# A46 Newark Bypass

Scheme Number: TR010065

**Applicant's Response to  
Environment Agency Relevant Representations**

<b>Version</b>	<b>Date</b>	<b>Status of Version</b>
Rev 0	October 2024	Deadline 1

Figure 10: Slough Dyke realignment – extract from AS-007 (General Arrangement Plans) Sheet 25005

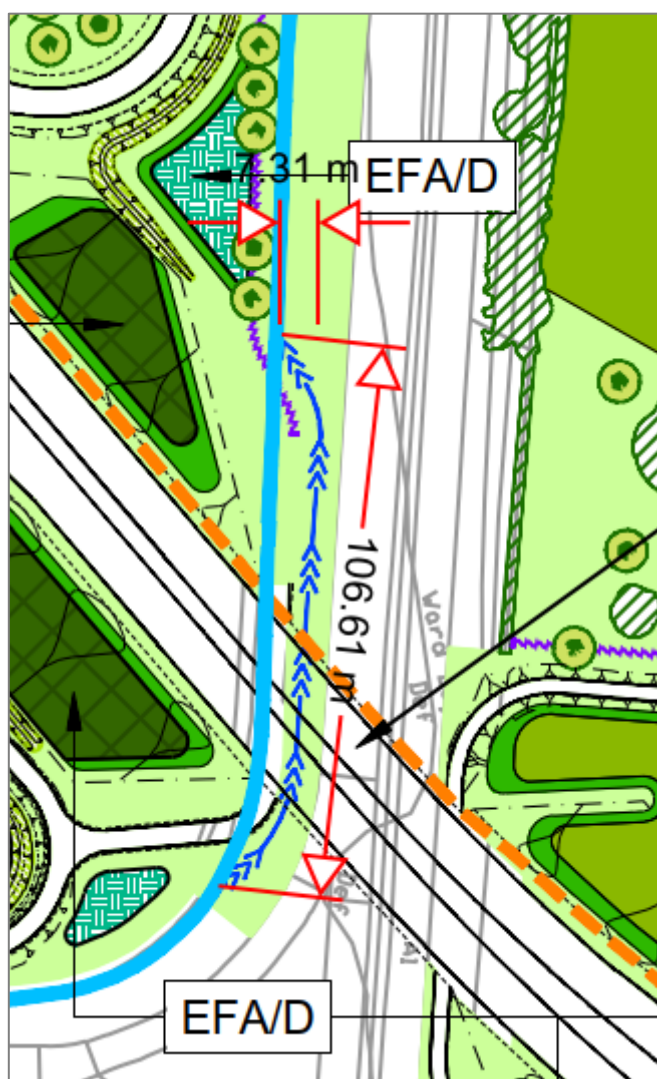
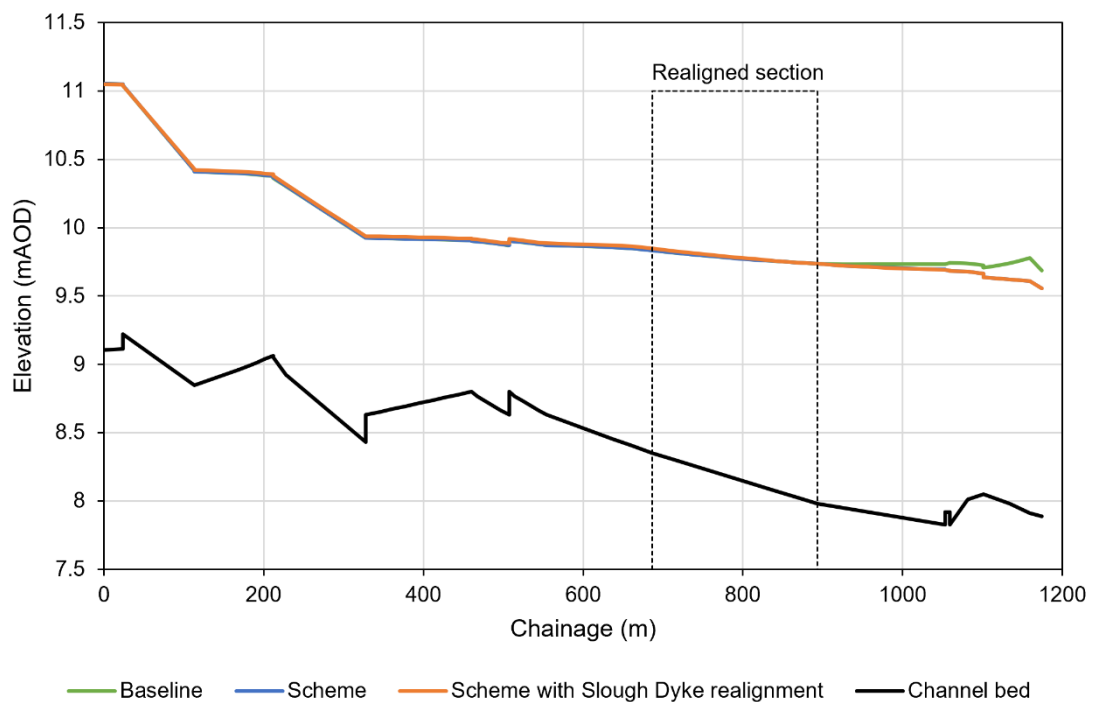
Environment Agency position		Applicant response
<b>Issue</b>	No detailed drawings for the Slough Dyke realignment have been provided and the realignment has also not been represented within the hydraulic modelling undertaken.	discussed with the Environment Agency in a meeting on the 05/09/2024, it was agreed to perform a simplified model run including the change to the Slough Dyke. The results from this are included in section 4 of the Hydraulic Modelling Technical Note.
<b>Impact</b>	The realignment of the Slough Dyke (as mentioned in paragraph 3.3.28 and shown in Figure 3-2 of the FRA) is necessary to facilitate the proposed scheme's layout. However, no detailed plans for the realignment have been provided to enable a more thorough assessment of the flood risk implications of the realignment. Although FRA paragraph 3.3.29 states the realignment is 'not predicted to alter the current hydraulics, and therefore flooding regime of this watercourse in the local area', further evidence is required to support this. Currently paragraph 6.1.5 of the 'A46 Newark Trent 2023 Fluvial Hydraulic Modelling Report' (FRA Appendix A) states "the Slough Dyke watercourse alignment was retained from its original hydraulic model", but we would expect the updated hydraulic modelling to account for this realigned channel to give a more accurate representation of the proposed scheme and to better understand the flood implications. Without this information we cannot be confident in our assessment of the flood risks, both to the development and to third parties, resulting from the realignment, and what could be done to mitigate any potential flood risks.

<b>Solution</b>	Detailed drawings should be provided and with-mitigation scheme modelling re-run with the realignment to understand the flood risk impacts.	
<b>EAFR-008: Interaction with Environment Agency flood defences</b>		
<b>Document references</b>	<a href="#">APP-177</a> – 6.3 Environmental Statement - Appendix 13.2 Flood Risk Assessment (ref. TR010065/APP/6.3, Revision 1, April 2024)	<p>The Applicant confirms the Scheme interacts with two Environment Agency flood defences. Information on the flood defences was discussed with the Environment Agency on 5 September 2024 in a meeting.</p> <p>The Crees Lane Embankment is a 239 metre long flood defence embankment which is located on the south bank of the River Trent between the A46 and Cress Lane. The embankment is constructed from clay with a clay key penetrating 1 metre below ground level. An access track, including bridleway 2, is located on top of the embankment.</p> <p>The new Windmill viaduct (Works No 7) spans over the flood defence embankment with no permanent detriment to its location or structure. The temporary works area for the construction of the bridge (Works No 127) will require a crushed stone platform to be laid to support the construction plant that will be required to construct the bridge, such as piling rigs and cranes. This stone platform would be laid against the existing flood structure and will not reduce its structural integrity. Upon completion of the new bridge structure the temporary works will be removed and the land reinstated to previous use. The bridleway (BW2) and access track (Works No 6 as shown on the Works Plans [AS-005] are re-opened following completion of construction of the bridge and the reinstatement of Works No 127. Works No 6 provides vehicle and foot access to the Crees Lane Embankment for inspection and maintenance works.</p> <p>The Newark Roundabout Embankment is a 325 metre long embankment located to the southeast of the A46 between Kelham Road and the southeast quadrant of the Cattle Market Roundabout. The embankment is constructed from Marl with a shear key that protrudes 1 metre into the ground under the center of the bund. There are also two grout curtain walls through the bund.</p> <p>Works No 40 as shown on the Works Plans [AS-005] is required for the widening for the new Cattle Market junction and interfaces with the eastern end of the flood defence. The southeast corner of the new roundabout will incorporate the last 10 meters of the eastern end of the flood embankment within the earthworks for the new roundabout. The new earthworks will be benched into the existing embankment to form a solid, homogeneous structure. The flood bund will not be compromised during the construction works, and the EA's existing access will be maintained.</p> <p>In relation to Crees Lane floodbank the Standard of Protection (SOP) is demonstrated to be 1 in 100 year + 39% climate change in the Scheme hydraulic model, however other routes result in flooding behind the defence in more frequent SOPs.</p> <p>In relation to Newark Roundabout Embankment similarly, the Standard of Protection (SOP) is demonstrated to be 1 in 100 year + 39% climate change in the Scheme hydraulic model, however other routes result in flooding behind the defence in more frequent SOPs.</p>

**Figure 3-2 Interface with Cree's Lane embankment**

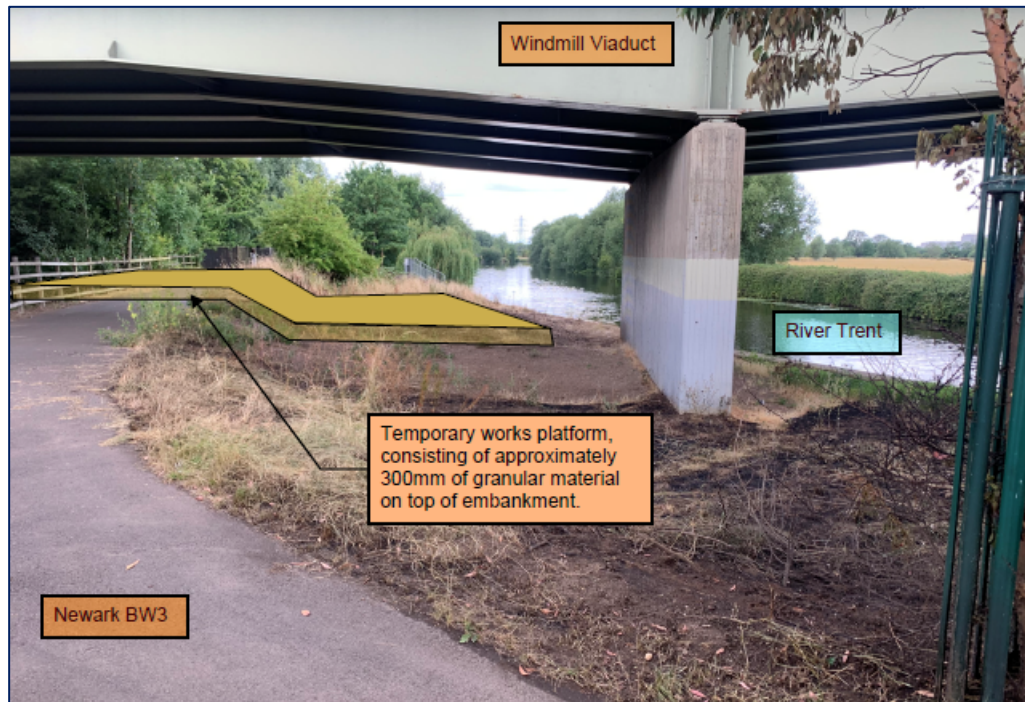
<b>Issue</b>	There is limited information available on the Scheme's interaction with the existing Environment Agency flood defences. The FRA mentions that the Scheme will 'tie-in' with existing Environment Agency flood defences (see paragraphs 3.4.2 and 7.7.2), but there is no explanation for how this will occur, or how it will be ensured that there will be no detriment to the defences.	
<b>Impact</b>	<ul style="list-style-type: none"> <li>FRA paragraph 7.7.2 states that the "scheme design directly interfaces with these flood defences and suitable measures have been put in place in order that the existing defences are not structurally compromised or altered in terms of crest height". However, without further details of how this interface will be managed, we cannot confirm whether proposals are acceptable.</li> <li>There is no evidence to demonstrate that the proposal will not restrict essential maintenance and emergency access to the defences (the permanent retention of a continuous unobstructed area is an essential requirement for future maintenance and/or improvement works), or whether the proposed development is likely to adversely affect the construction and stability of the flood defences, which will compromise their function.</li> </ul>

<b>Solution</b>	<ul style="list-style-type: none"> <li>Further information should be provided on the current Standard of Protection (SoP) of the existing defences, their composition, current condition, and inspection regime.</li> <li>Detailed plans for areas around the defences, showing tie-in with the Scheme, should be provided. The lifetime of the defences should ideally be commensurate with the lifetime of the Scheme, so if this is not the case then the Applicant should consider opportunities to ensure they are brought up to the Scheme's lifetime.</li> </ul>	
<b>Additional comments</b>	<ul style="list-style-type: none"> <li>Although the detailed construction approach to works in/around the Environment Agency defences would be addressed under a flood risk activity permit, we still expect the DCO submission to be supported by the outline construction principles for how it will be ensured that the flood defences are not negatively impacted by the proposed scheme works.</li> <li>The Environment Agency would be keen to engage in further discussions on flood defences as soon as information is available.</li> </ul>
